**Consultation Response from KC,
Highways Development Management**

2024/92153 Land to the south of, 5-25, Clay Well, Golcar, Huddersfield, HD7 4FD

Erection of 13 dwellings with associated access road and landscaping

Date Responded: 19th August 2024

DRAWING
Proposed Elevations - Plot 4 & 5 - Sheet 1

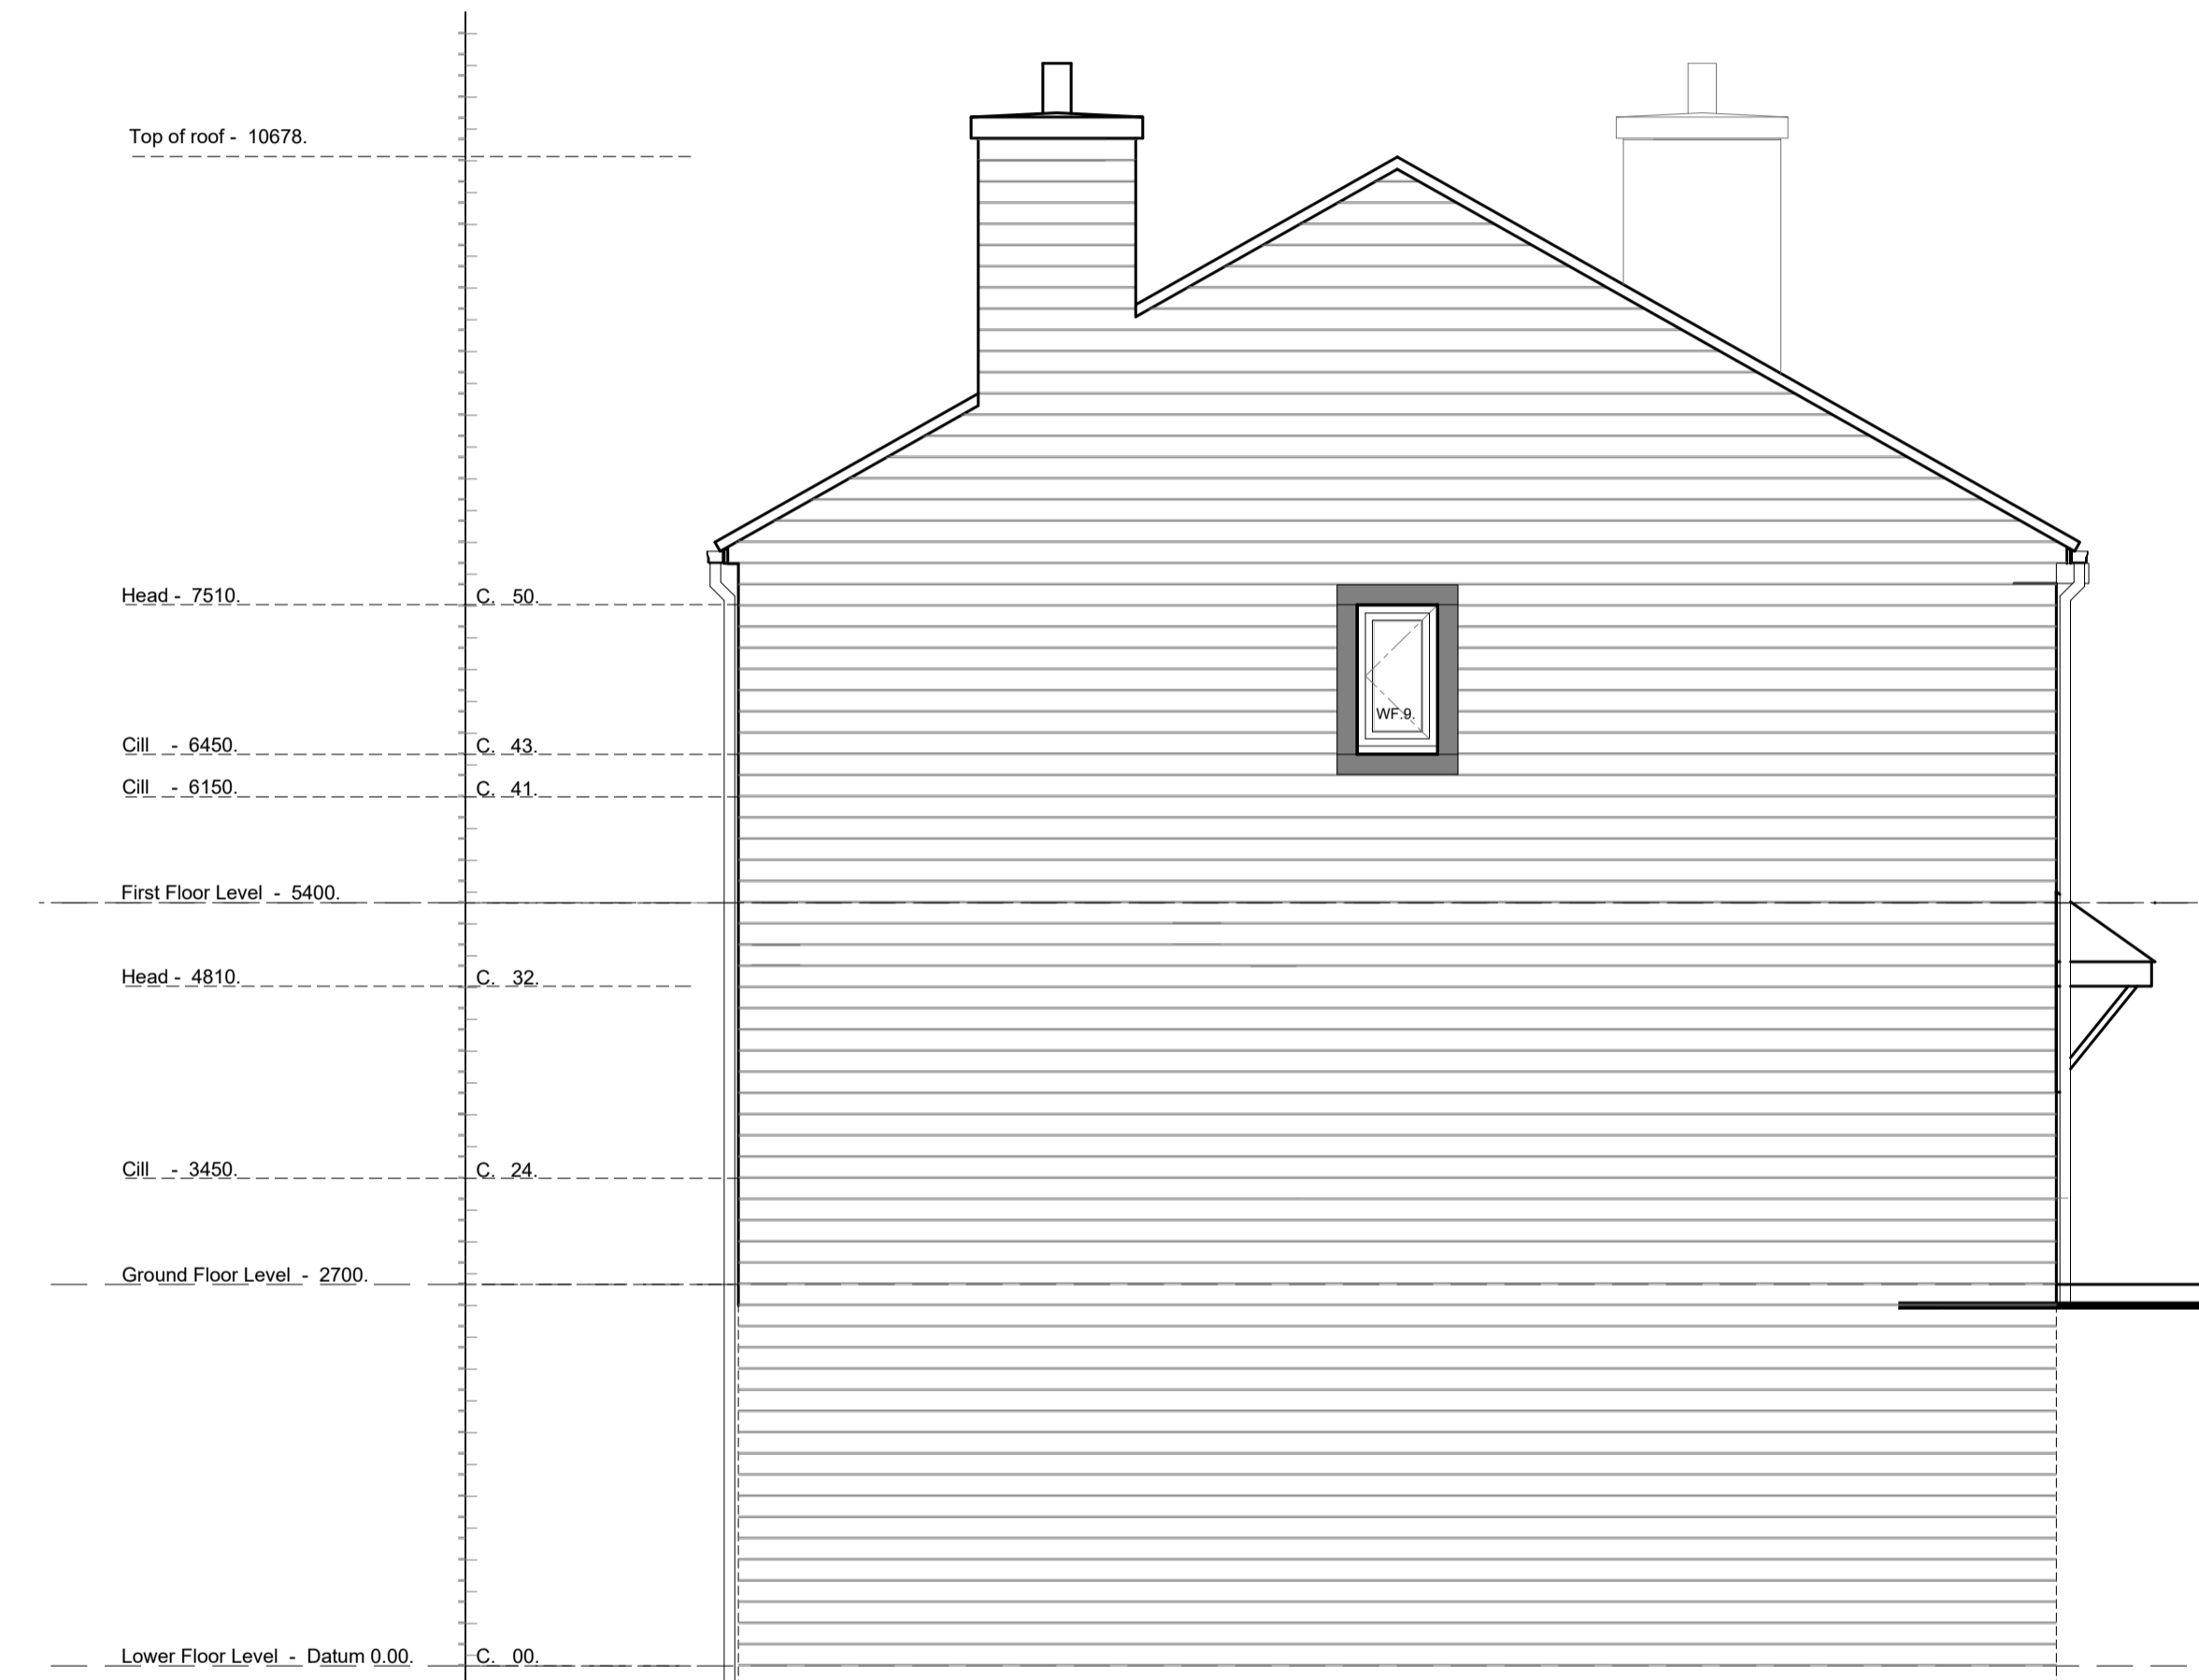
The proposed site layout, Drawing No. R-087360 Rev. 'C', submitted with the current application is virtually identical to the approved site plan Drawing No. M4419 (PA) 01 Rev. 'H' submitted under application 2021/91384. The only noticeable changes being the parking for plot 5, and the private drive serving plots 11 and 12. The revised parking arrangement for plot 5 can still accommodate two off-street parking spaces and is considered acceptable. It is noted that the amended private drive, which now serves plots 11 and 12, previously the drive served only plot 12, has been extended reducing the size of the approved turning head. Review of the swept paths submitted with application 2021/91384 suggest that a waste collection vehicle using the turning head would encroach on to the private drive when undertaking turning manoeuvres, which is not acceptable. The turning head needs to revert to the approved layout (reducing length of private drive), or alternatively demonstrate using swept path analysis that the as built turning head can accommodate an 11.85m waste collection vehicle.
